**KIRKLEES METROPOLITAN COUNCIL
INVESTMENT & REGENERATION SERVICE**

DELEGATED DECISION TO DETERMINE PLANNING APPLICATIONS

Reference No:	2026/62/90223/E
Site Address:	5, Park Croft, Dewsbury, WF13 2LN
Description:	Erection of first floor rear extension
Recommending Officer:	Jennifer Booth

DECISION - REFUSED

PROPOSED FIRST FLOOR PLAN

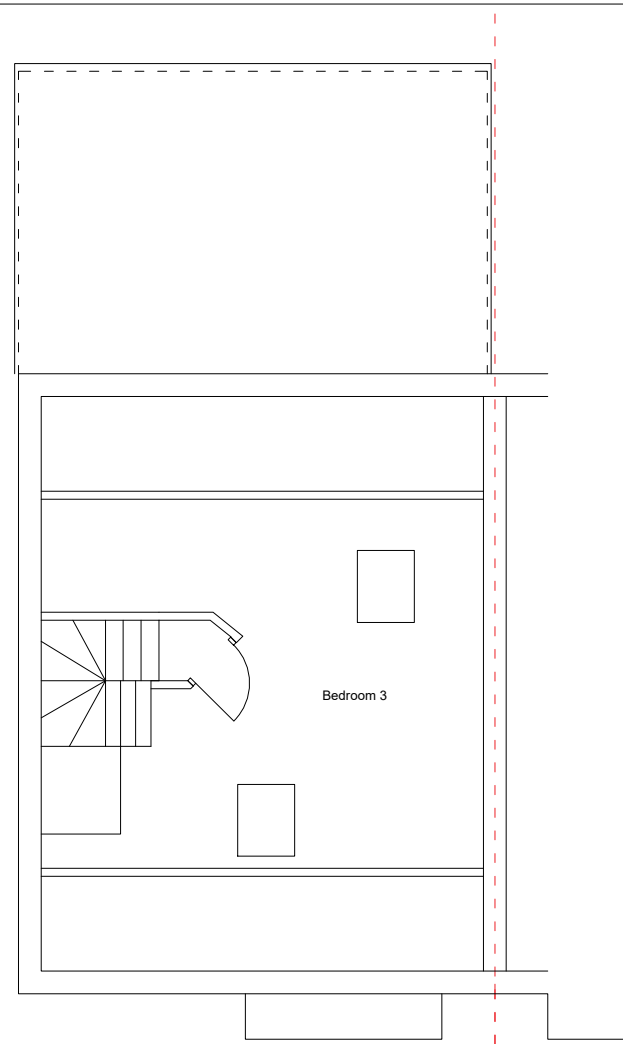
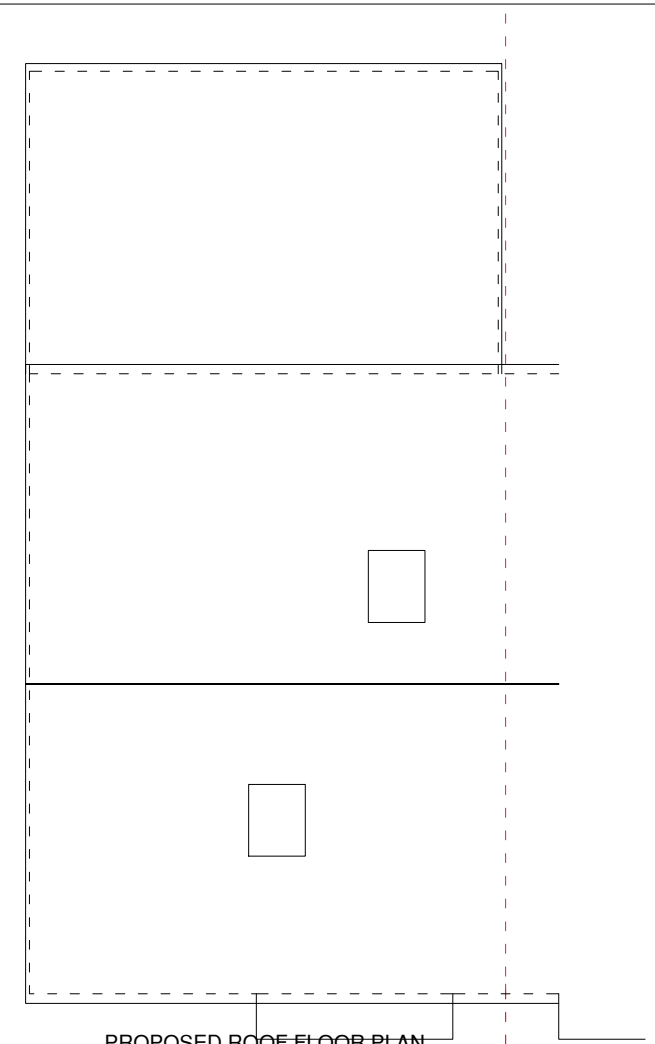
The extension would be constructed along the shared boundary with the adjoining property and would be close to the neighbour's bedroom window and would result in an overbearing impact. Given the position of the extension to the south of the neighbour, there would also be overshadowing from the middle of the day. The windows would be in the rear elevation and would look into the applicants own amenity space with limited views over the rear most extent of the neighbour's garden area.

Having considered the above factors, the proposals are considered to result in overshadowing and overbearing of the bedroom window of the adjoining property, thereby failing to comply with Policy LP24 of the Kirklees Local Plan (b) in terms of the amenities of neighbouring properties, Key Design Principles 3, 5, 6 & 7 of the House Extensions & Alterations SPD and Chapter 12 of the National Planning Policy Framework.

There are concerns with the impact on the adjoining property as the extension would result in overbearing of the first floor window. There are also concerns with the flat roof design at first floor which is poor design. Amended plans have not been sought.

PROPOSED SIDE ELEVATION  
(North)

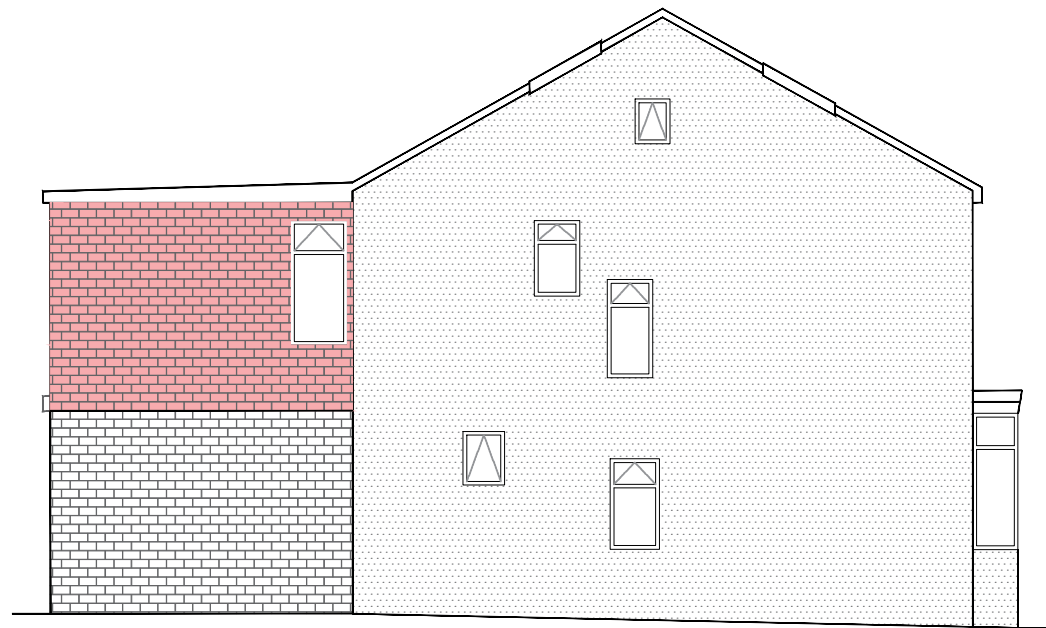
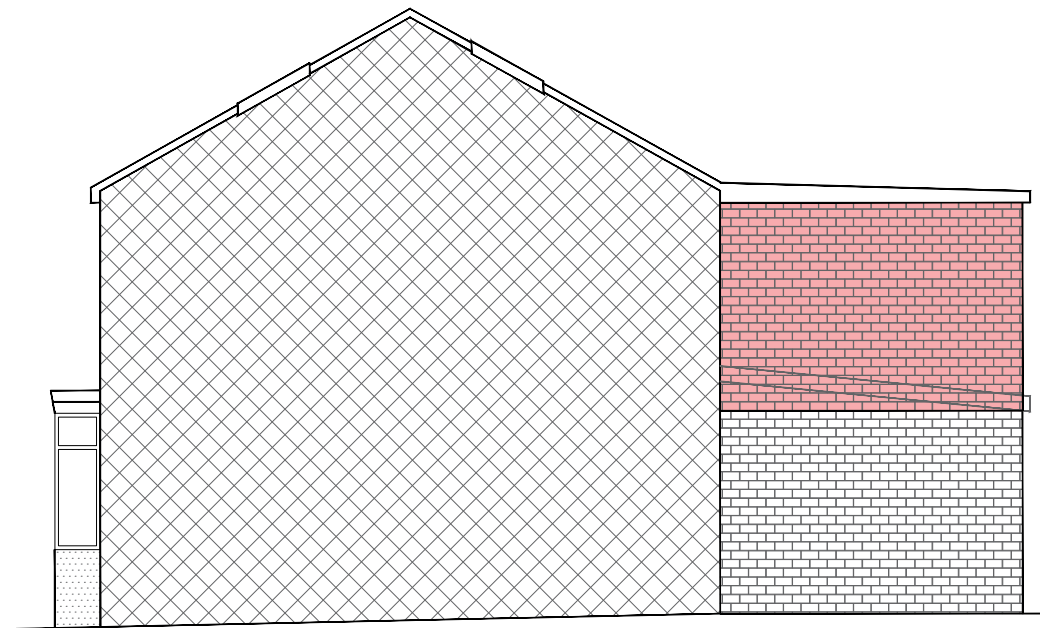
The proposed first-floor rear extension would not result in significant harm to visual amenity in terms of its siting and scale, and the use of walling materials to match the main dwelling would assist in integrating the development with the host property. However, the flat-roof represents a poor standard of design that fails to reflect the existing roof form of the dwelling. As a result, the extension would appear incongruous and out of character with the established appearance of the property, to the detriment of the visual amenity of the area.

The proposed first floor rear extension, by reason of its flat roof design, would not represent good design and would result in an incongruous feature, out of character with the surroundings. To permit the proposals would be contrary to Policy LP24 of the Kirklees Local Plan, KDP1 & KDP2 of the House Extensions & Alterations SPD and Chapter 12 of the National Planning Policy Framework.

1. The proposed first floor rear extension, by reason of its flat roof, would not represent good design and would result in an incongruous feature, out of character with the host building and surrounding area. To permit the proposals would be contrary to Policy LP24 of the Kirklees Local Plan, KDP1 & KDP2 of the House Extensions & Alterations SPD and Chapter 12 of the National Planning Policy Framework.

2. The proposed first floor rear extension, due to its siting along the shared boundary with the adjoining dwelling would result in an overbearing impact and overshadowing in the afternoon of the bedroom window of the adjoining 7 Park Croft to the detriment of residential amenity of the occupants. To permit the proposals would be contrary to Policy LP24 of the Kirklees Local Plan, KDP5 & KDP6 of the House Extensions & Alterations SPD and Chapter 12 of the National Planning Policy Framework.
